DEVELOPMENT REVIEW BOARD

Code Enforcement Comments

DRB Project Number: 1011471

Application Number: 18DRB-70092

**Plat for
Tracts 2-A-3-C-1 & 2-A-3-C-2
McLeod Business Park
Being Comprised of
Tracts 2-A-3-C and 2-A-3-D
McLeod Business Park
City of Albuquerque
Bernalillo County, New Mexico
March 2018**

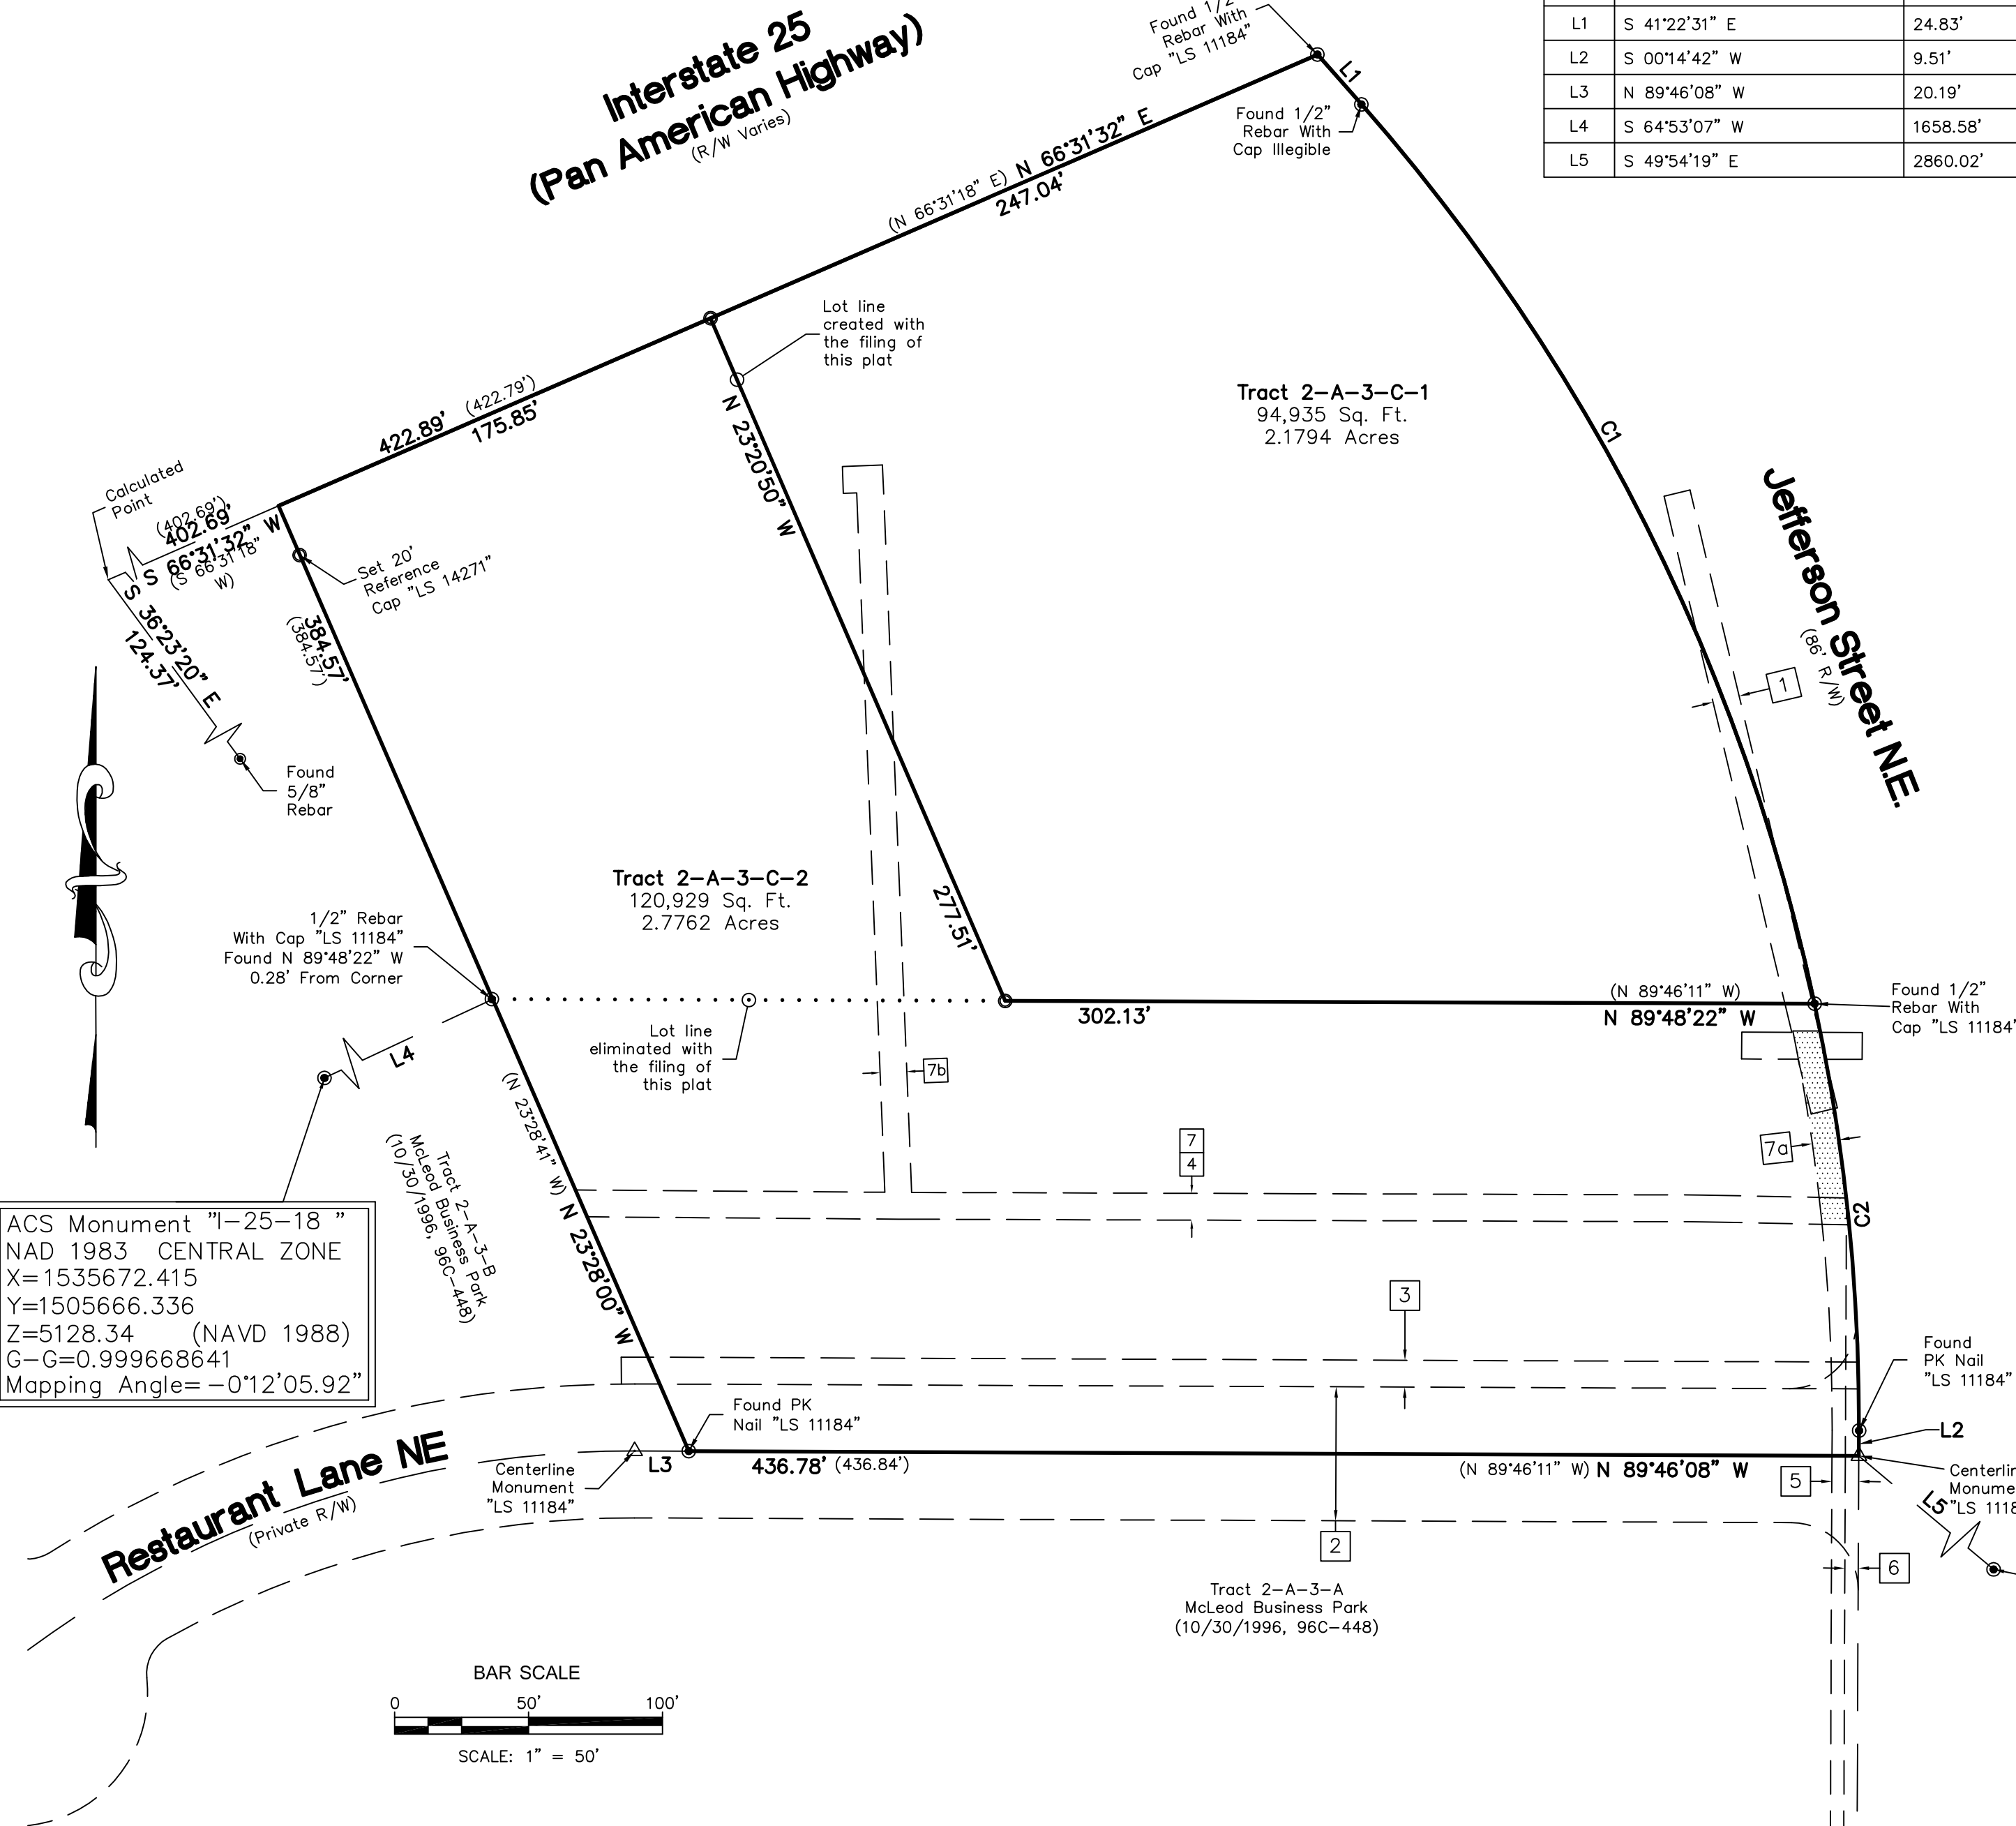
Is the existing building being demolished? If not parking must be provided as required for the existing building on the proposed site.
